From: Ryan Howser
Sent: Friday, December 1, 2023 9:44 AM
To: 'David Gorman'; Wayne Timura
Subject: FW: Eagle Rising and Kurie cul-de-sac

From: Elizabeth Nijkamp <ElizabethNijkamp@elpasoco.com>
Sent: Thursday, November 30, 2023 4:48 PM
To: Ryan Howser <RyanHowser@elpasoco.com>; Justin Kilgore <JustinKilgore@elpasoco.com>; Jeff Rice <JeffRice@elpasoco.com>
Cc: Joshua Palmer <JoshuaPalmer@elpasoco.com>; Gilbert LaForce <GilbertLaForce@elpasoco.com>
Subject: Eagle Rising and Kurie cul-de-sac

**EAGLE RISING FILING NO. 1**  
 A PORTION OF THE EAST HALF (E 1/2) OF SECTION 29, TOWNSHIP 12 SOUTH,  
 RANGE 65 WEST OF THE SIXTH PRINCIPAL MERIDIAN, EL PASO COUNTY, COLORADO

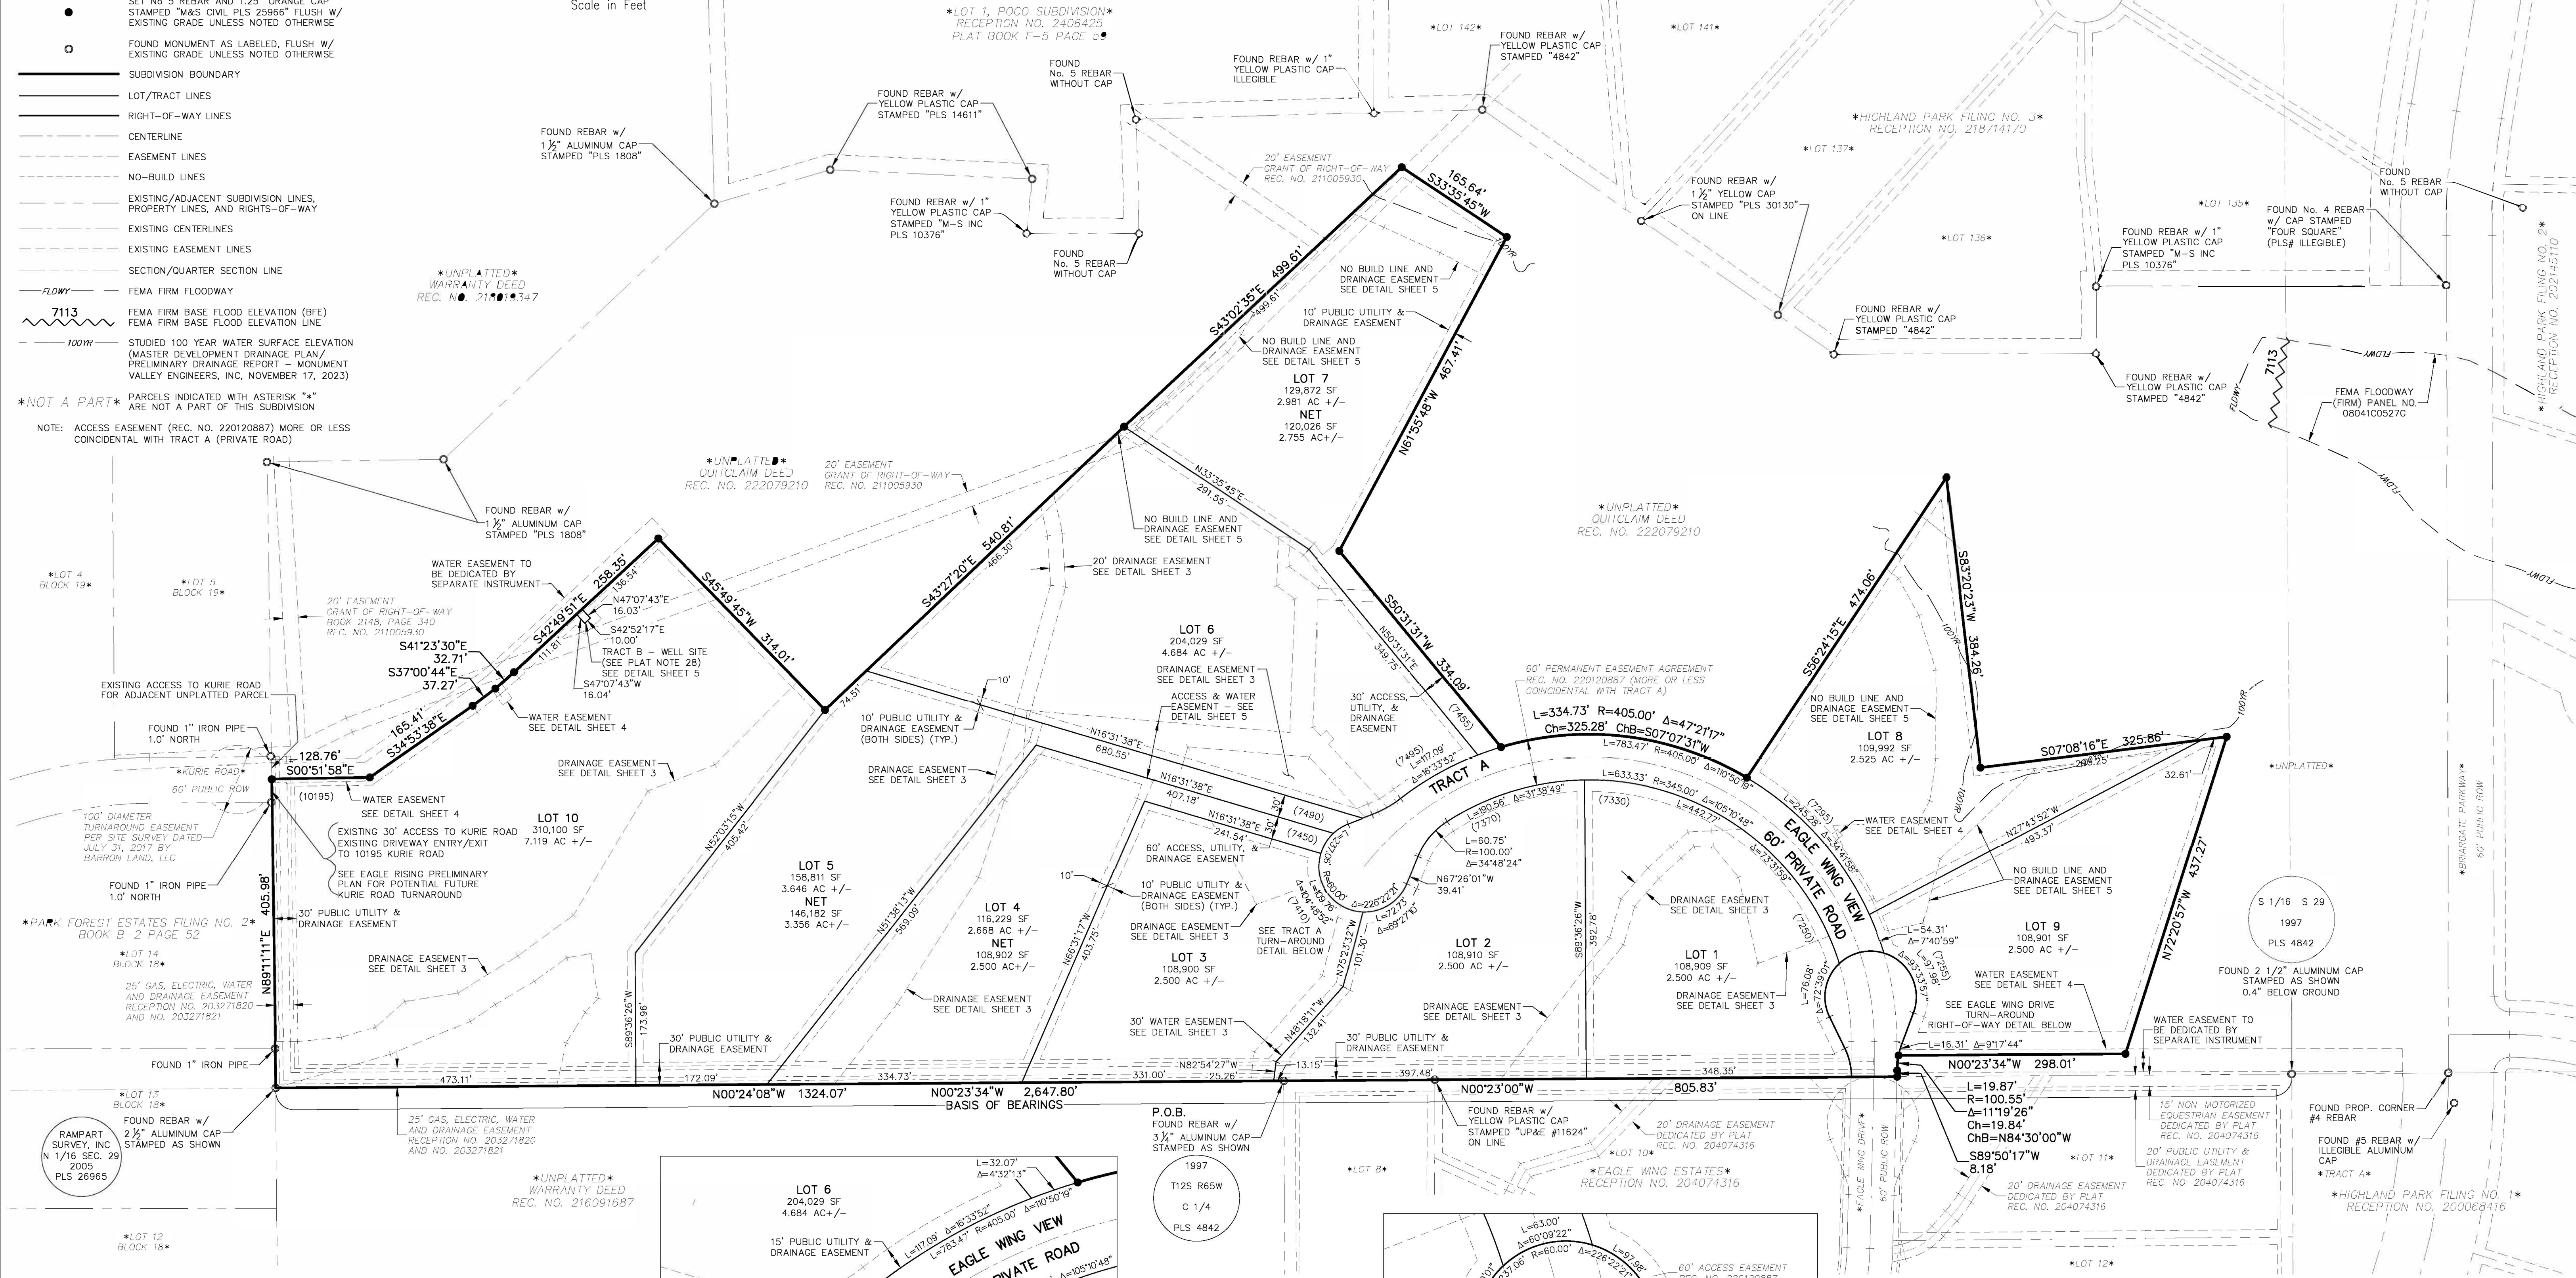
Can you please inform the applicant and place in the file that it is this department's position that any portion of the cul-de-sac that is within this subdivision plat should be platted as ROW at this time to accommodate the cul-de-sac shown, when the east side plats (the balance of the remainder parcel) they will be required to plat and construct the cul-de-sac.

The reason for this is due to existing ROW for the cul-de-sac on the adjacent property being substandard for a turnaround to be constructed to County standards. The County currently has a 60' ROW at this location with turnaround easements that are not sufficient for permanent use. The current approved prelim plan shows the addition of a cul-de-sac which is necessary for safe turnaround and snow removal. I feel that it would be a major amendment to the approved prelim plan to remove this feature.
